Our Ref: M/5/20/HH
Your Ref:

Town & Country Planning Act 1990 (as amended)
Town & Country Planning (Development Management Procedure) (England) Order 2015
Application for Planning Permission for Works or Extension to a Dwelling

Development Conversion and Extension of Detached Garage to Form Annexe
Location 15 Harefield Road Ancton Middleton-On-Sea

EXISTING FLOOR PLAN

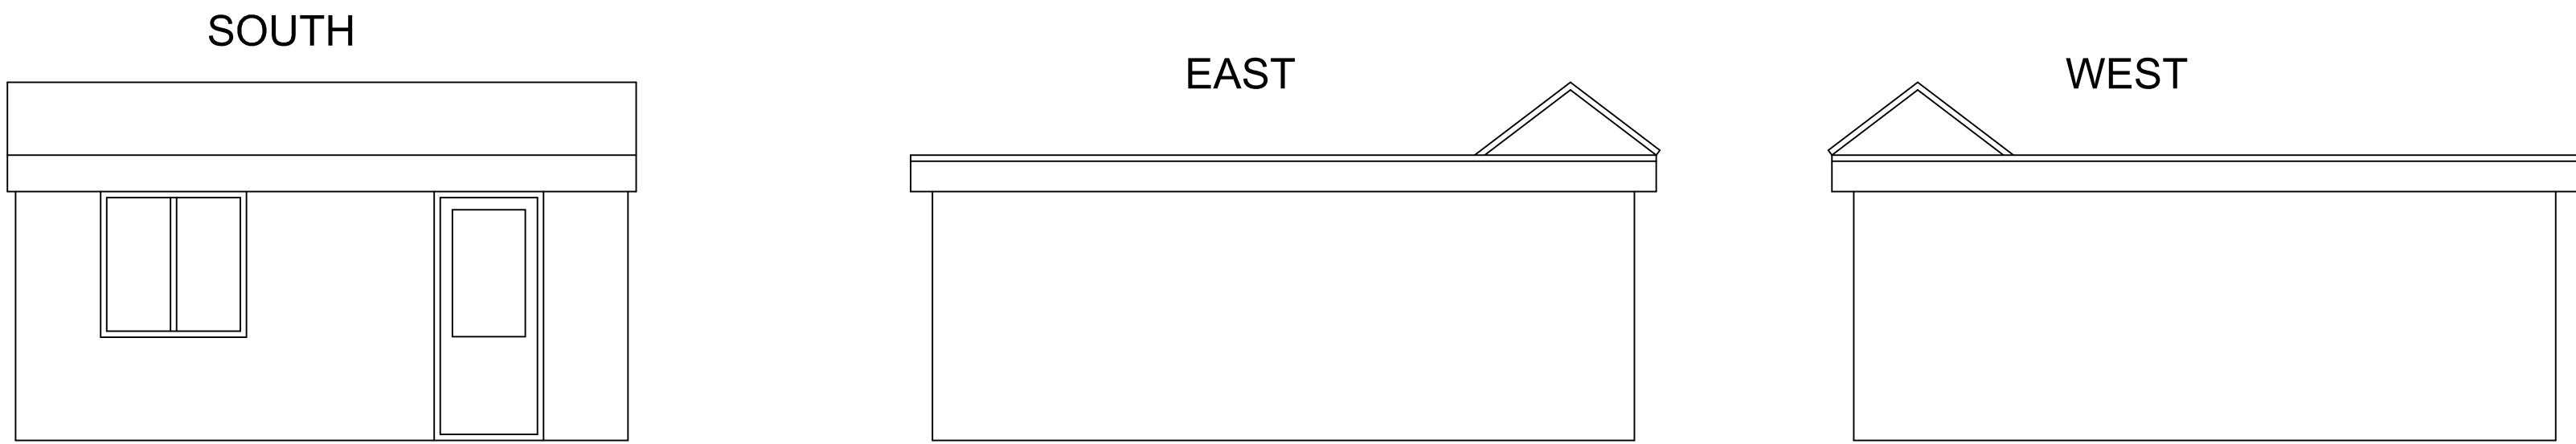
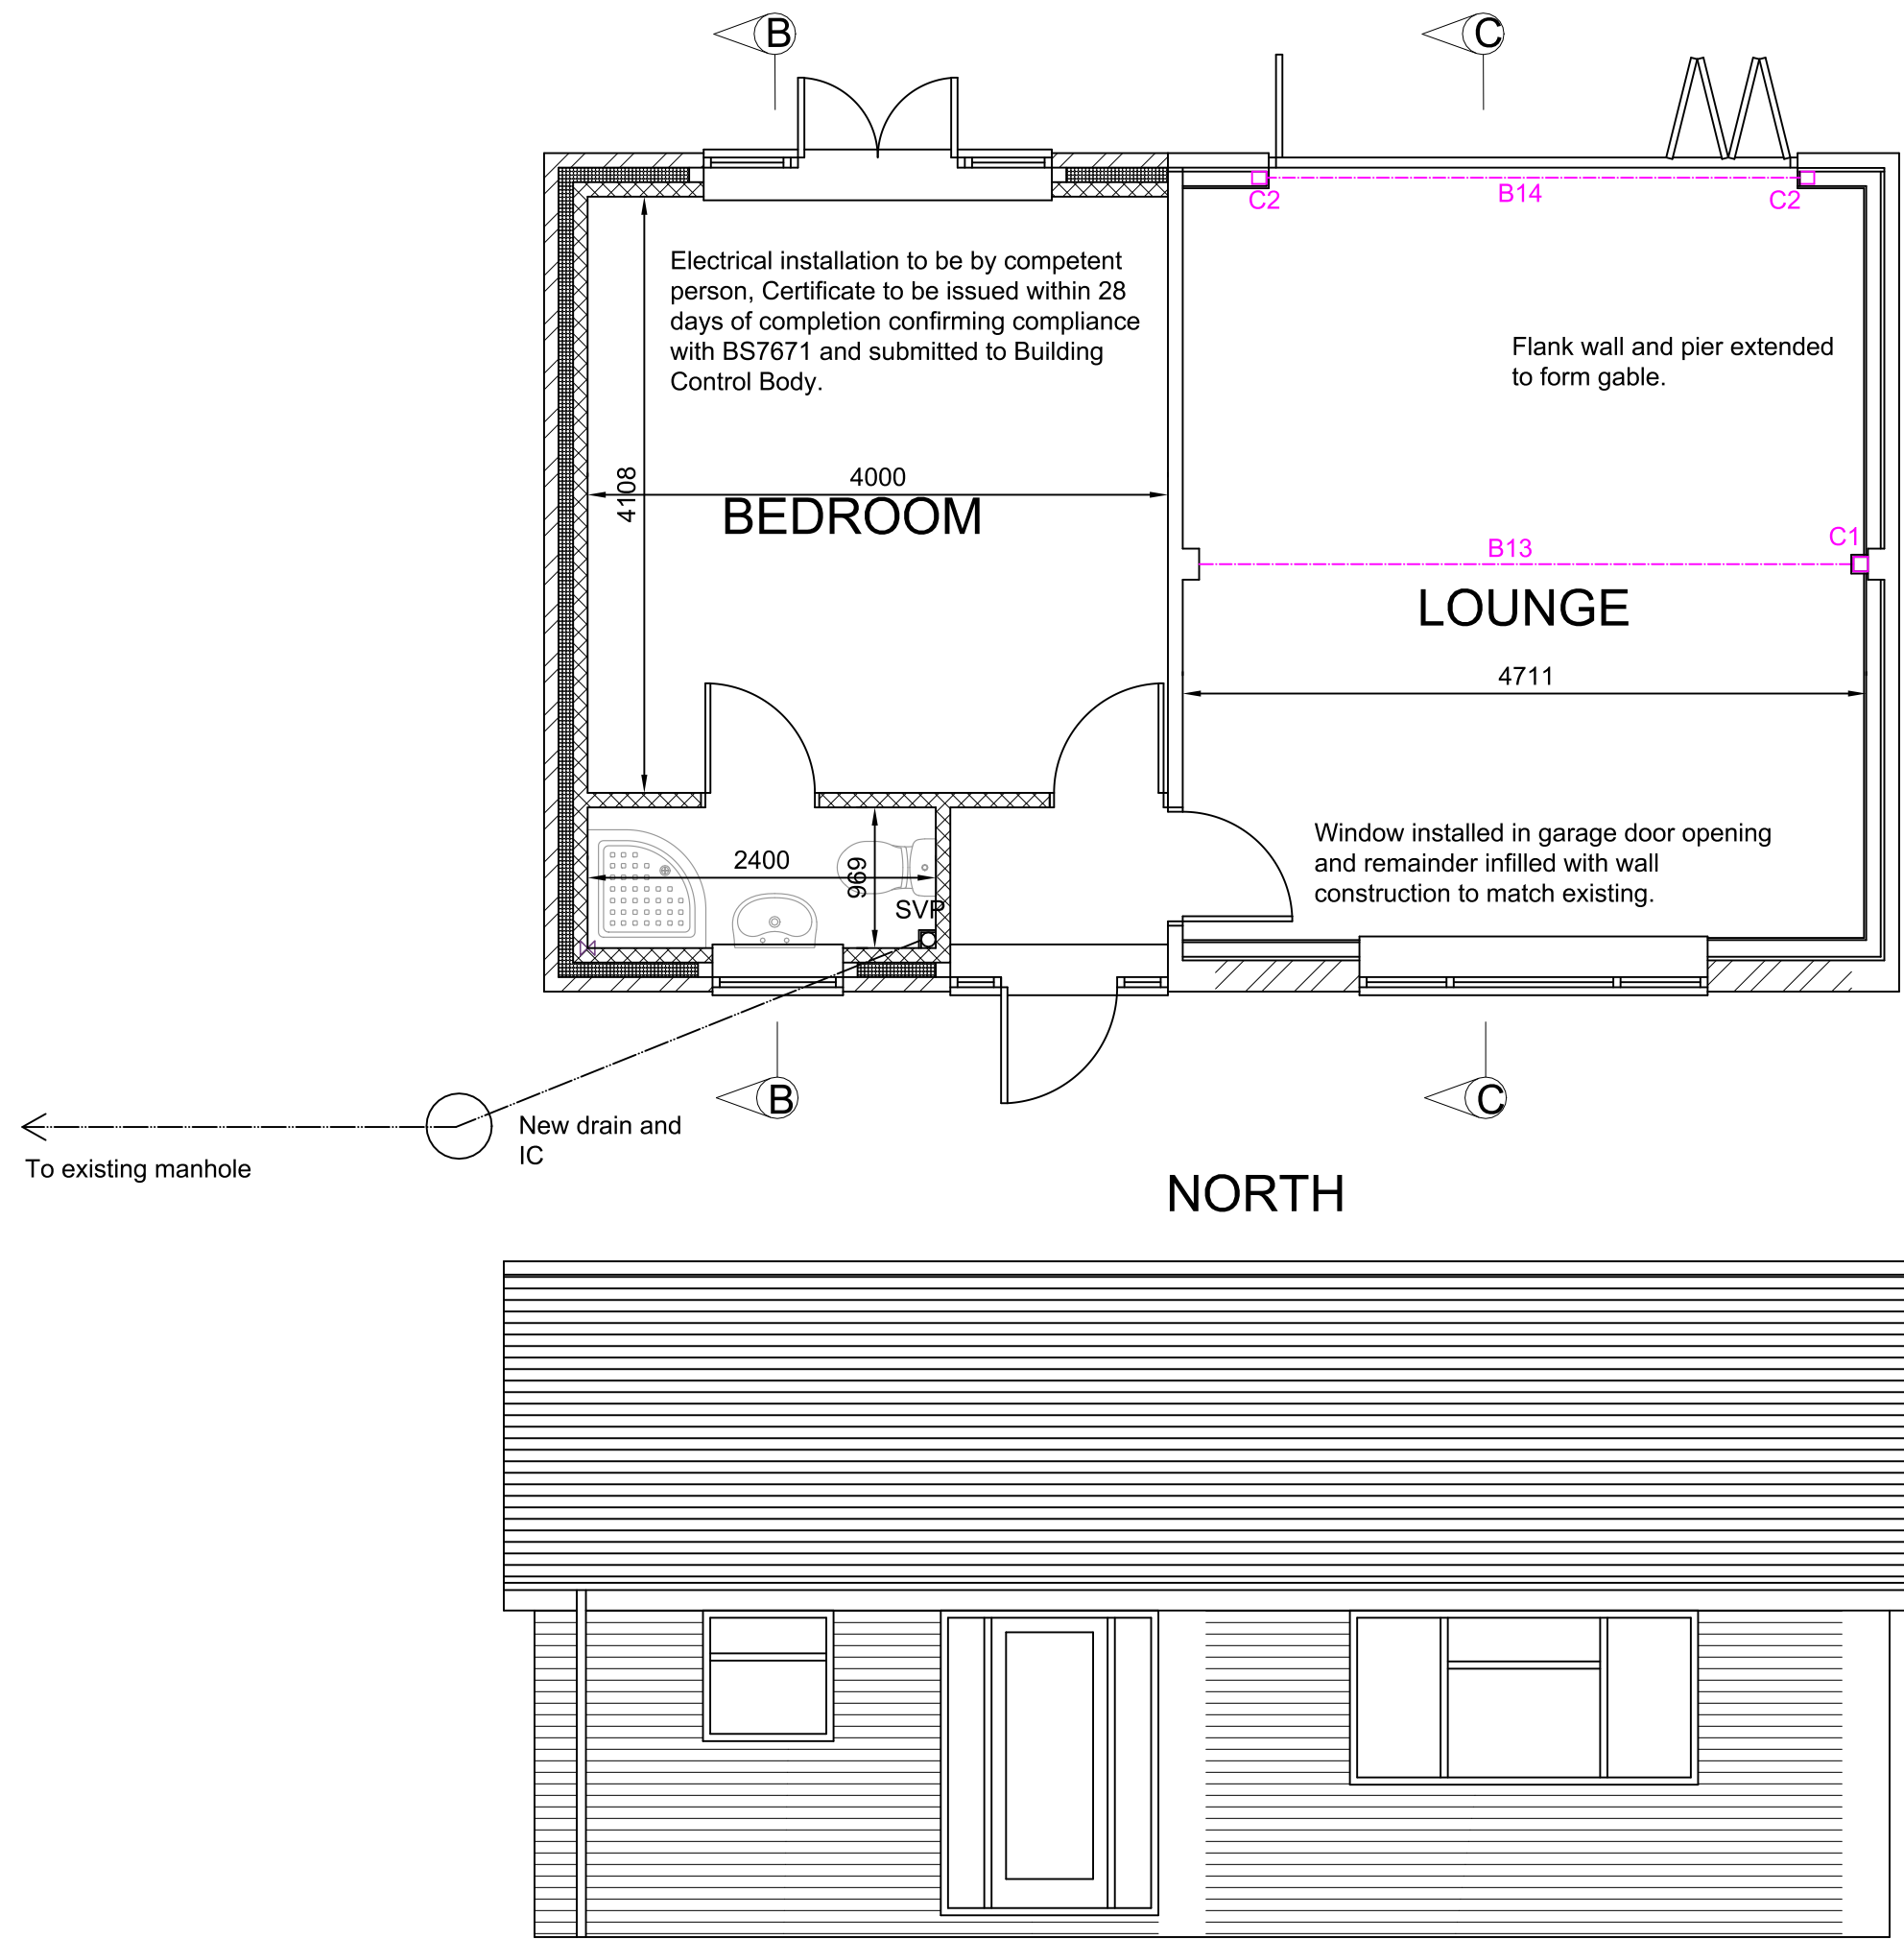
Room Labels: You are required to include room labels on all floor plans including the existing floor plans.

DRAWING BLOCK PLAN DATE: JANUARY 2020 DRAWN: T. Murray	SCALE 1/500
DRAWING: 20/01/6	REVISION:

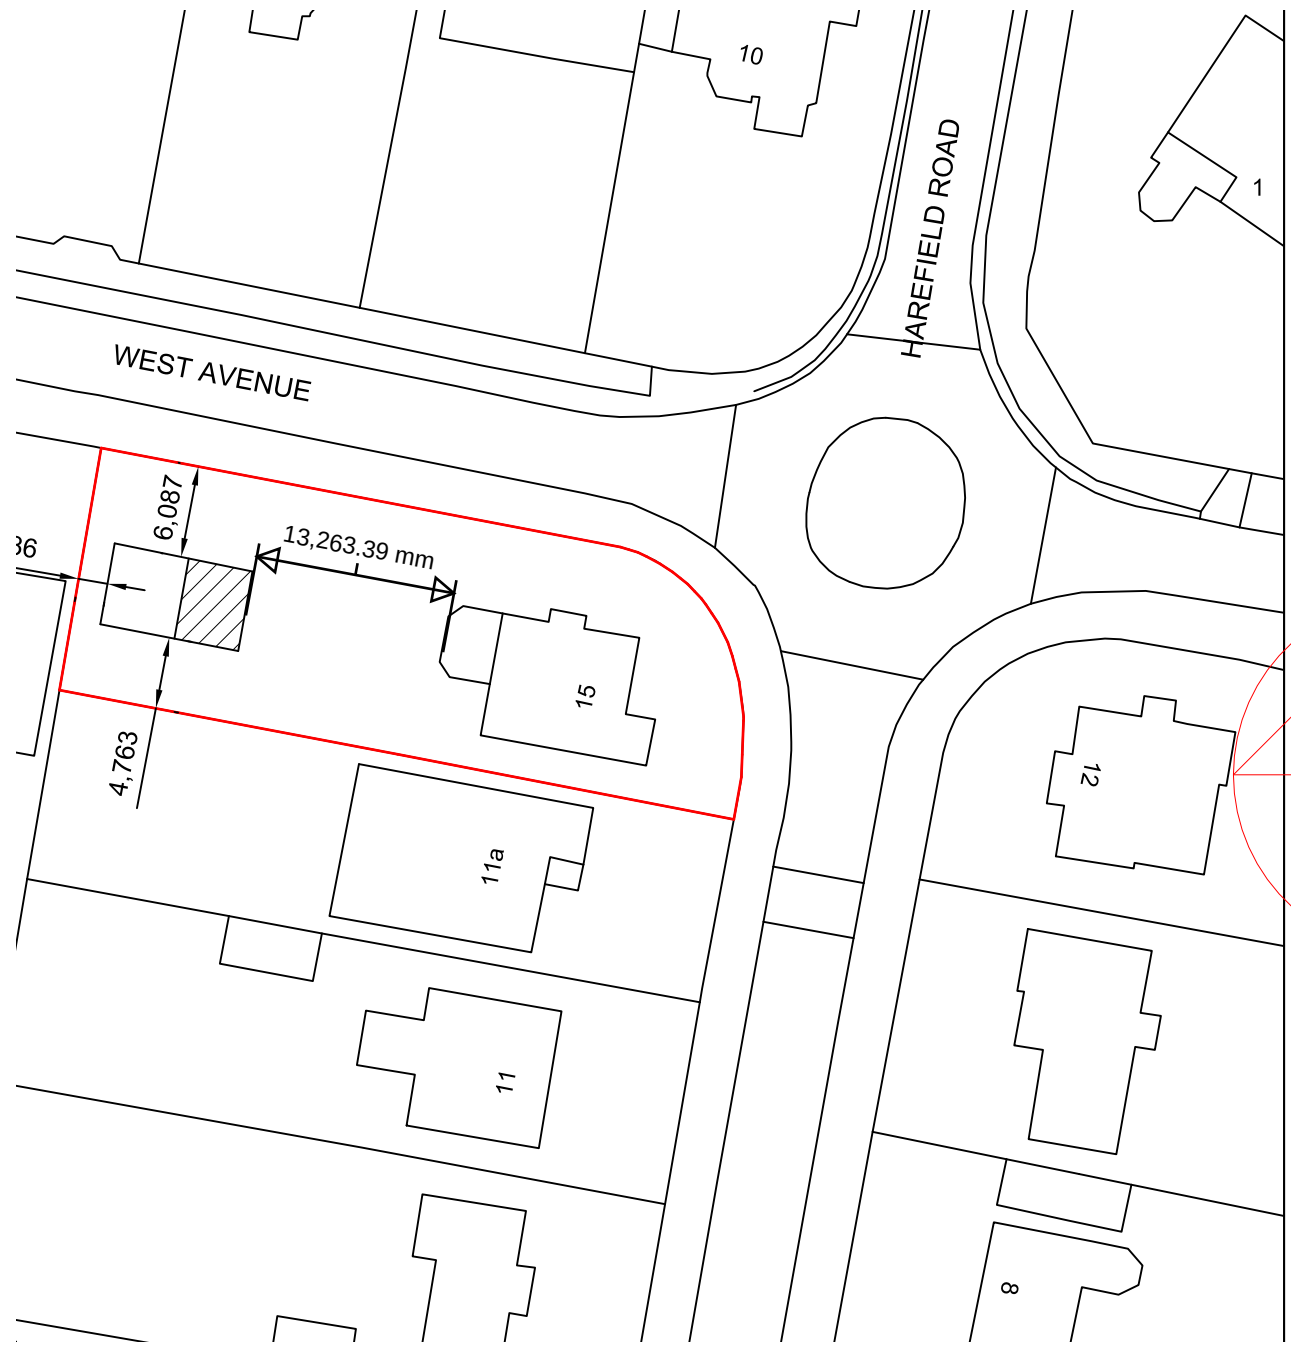
Block: You are required to include dimensions on the block plan from the proposed extension to all site boundaries.
